CITY OF ALBUQUERQUE

RE: **Durango at the Trails (File: C09D012)**
Drainage Report for Units 1 to 4
Engineer's Stamp Date 10-24-2014

40 20 0 40
1" = 40'

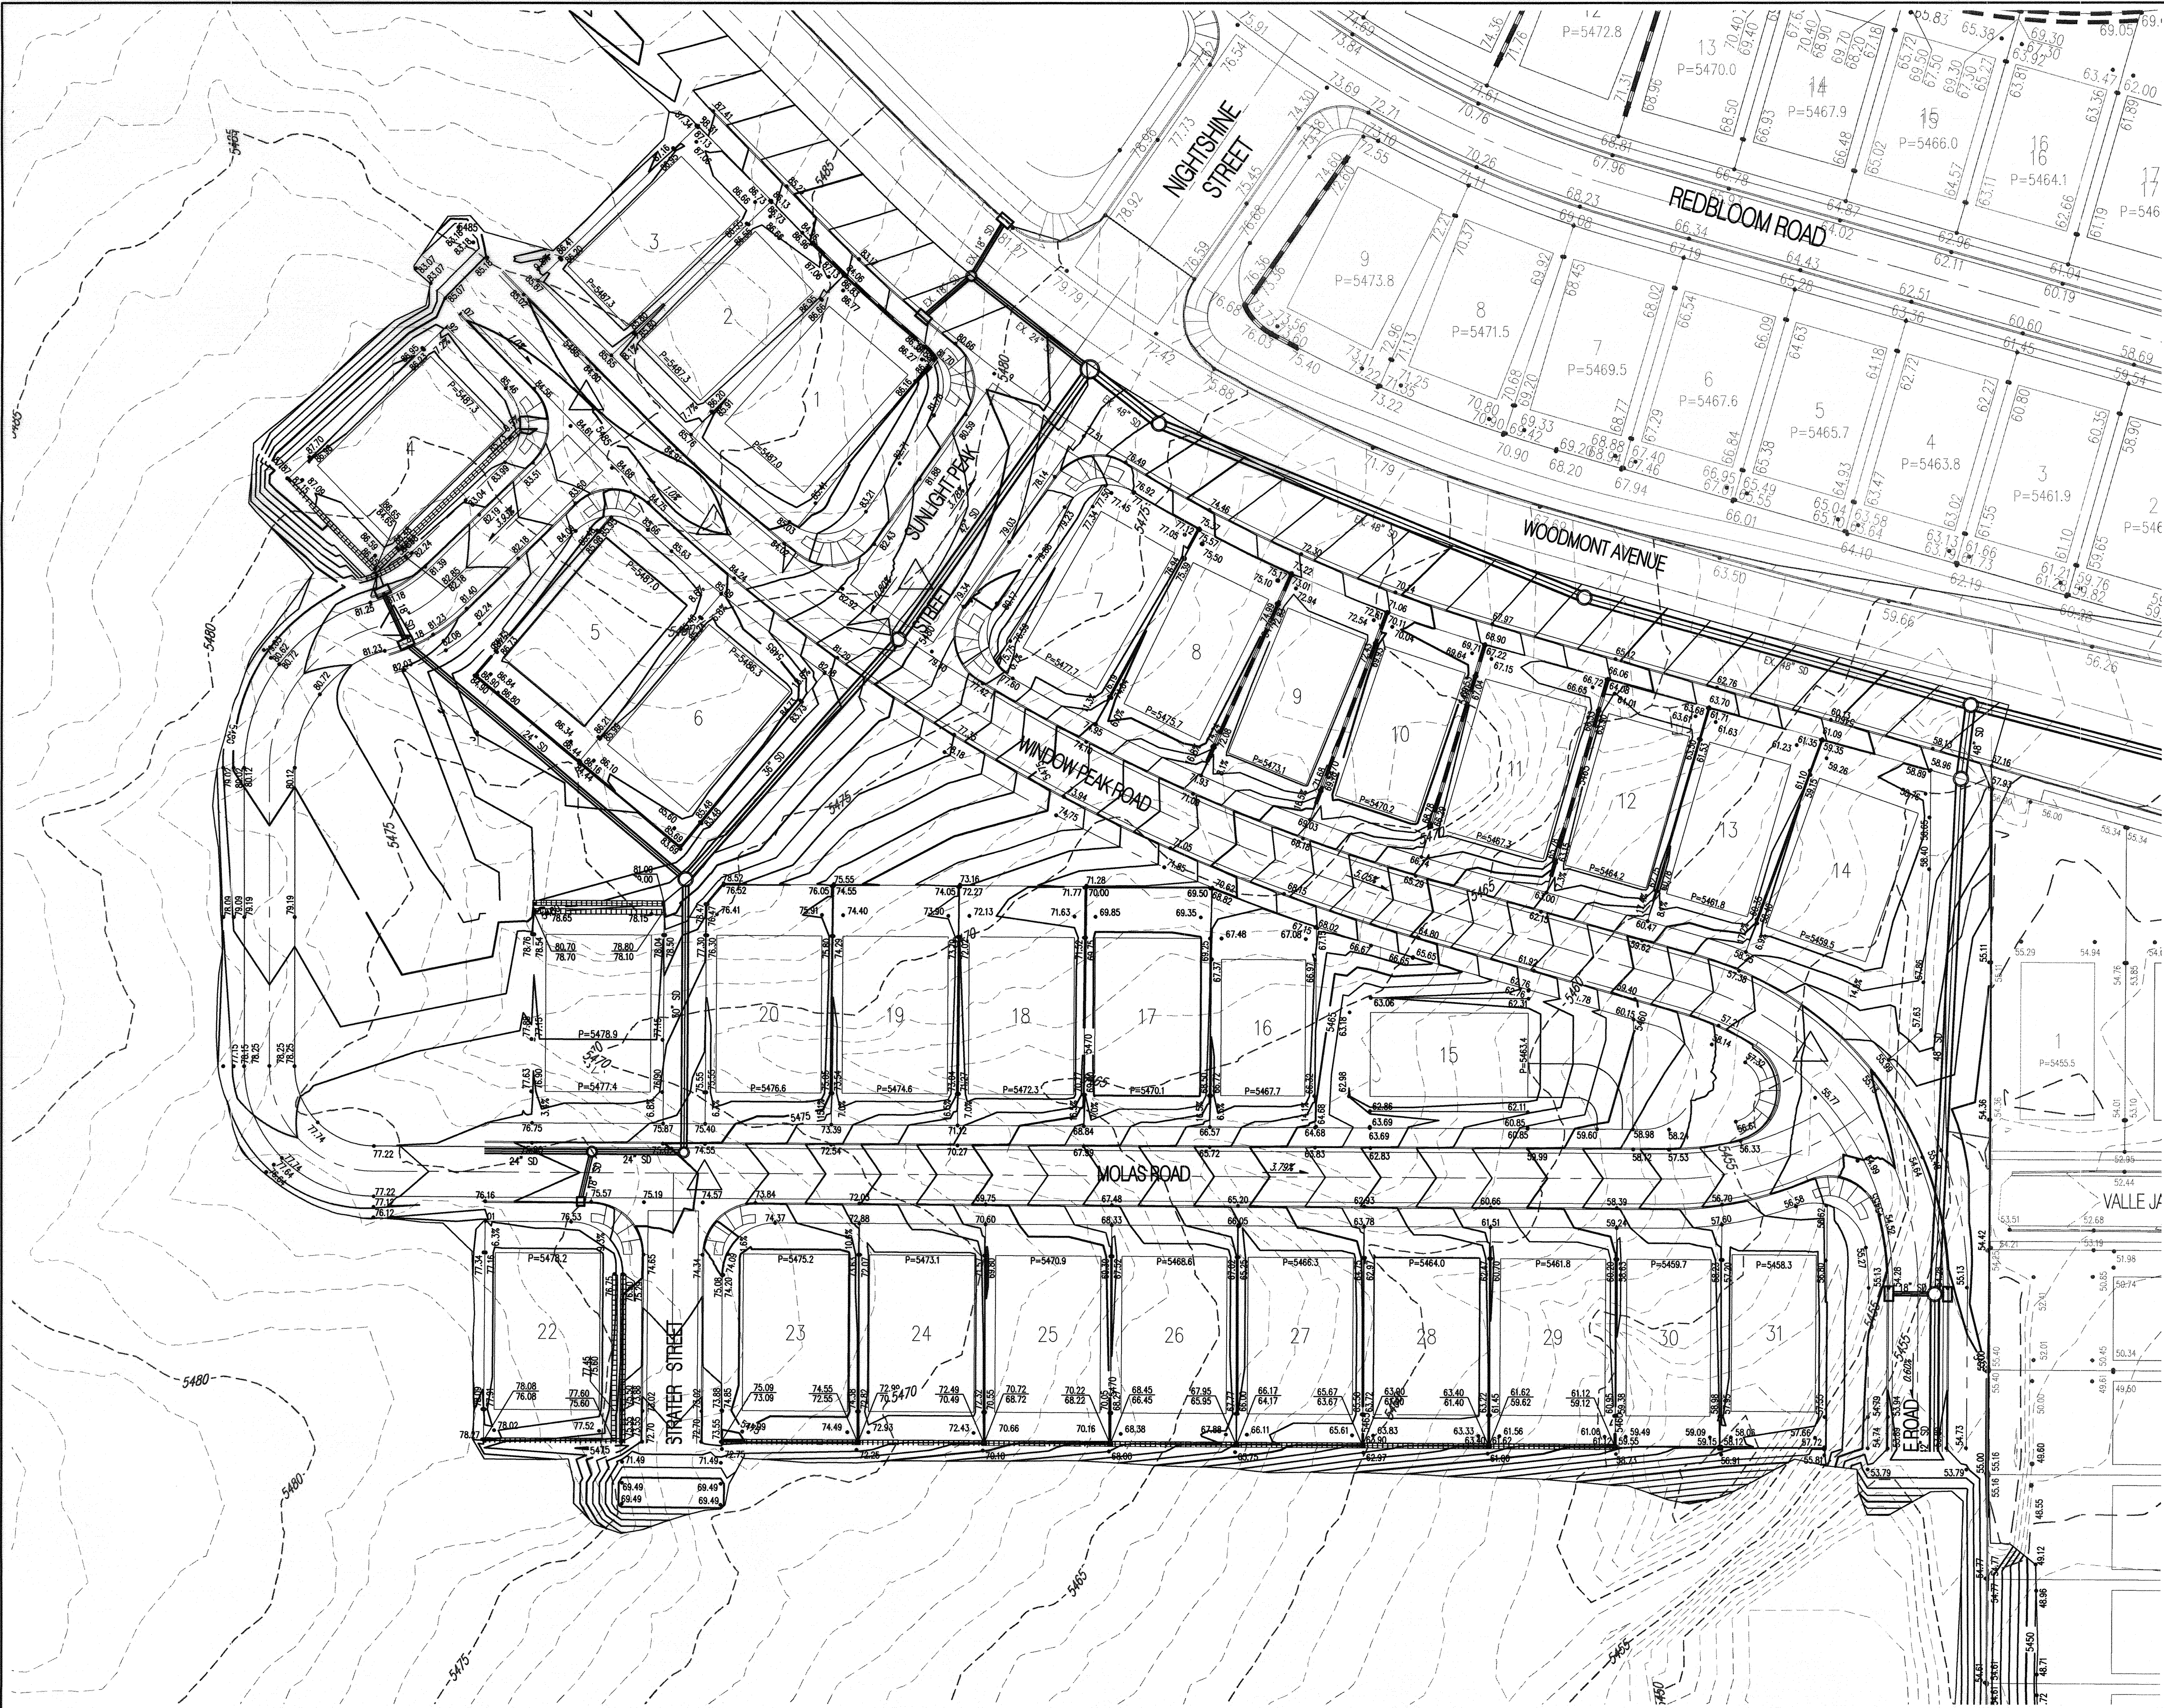
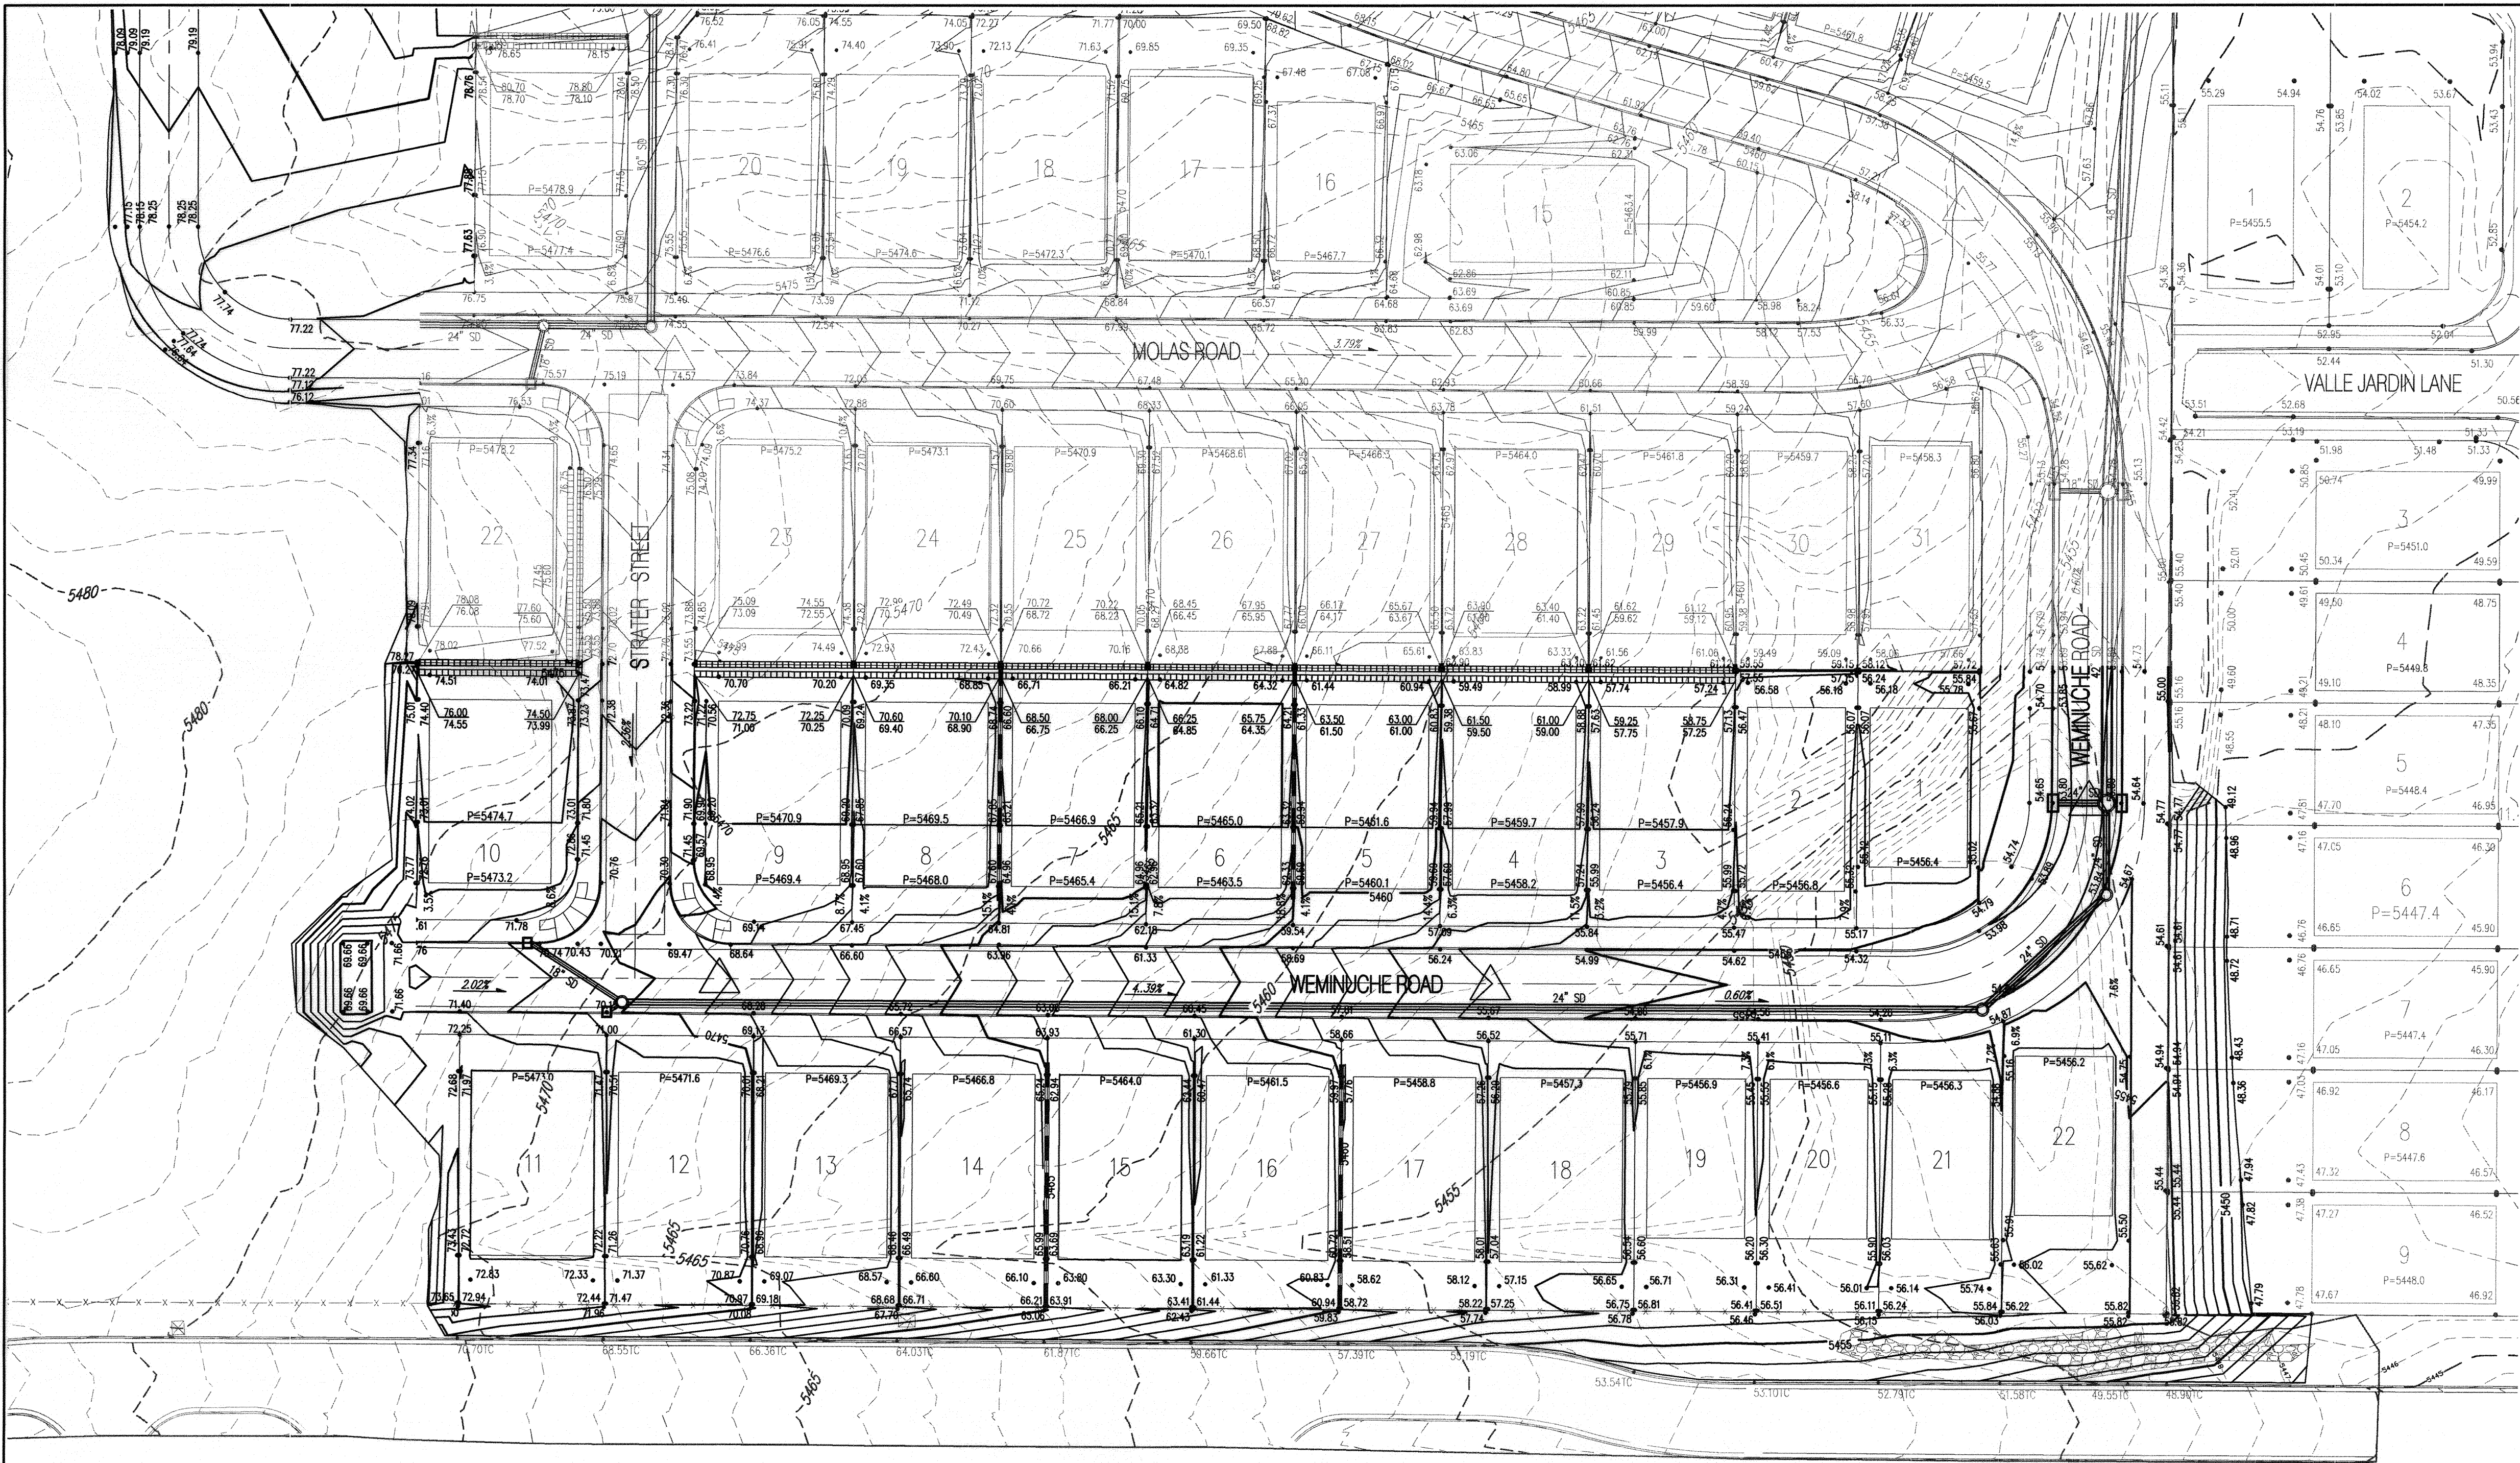
1. Units 1 thru 4 are to be phased. Provide an interim grading plan for each phase, showing sediment ponds and tie slopes.
2. Provide revised grading plan showing recent changes. Grades and retaining walls will be checked after this plan is submitted.
3. Revise I.L list with for separate line items for each run/size of pipe.
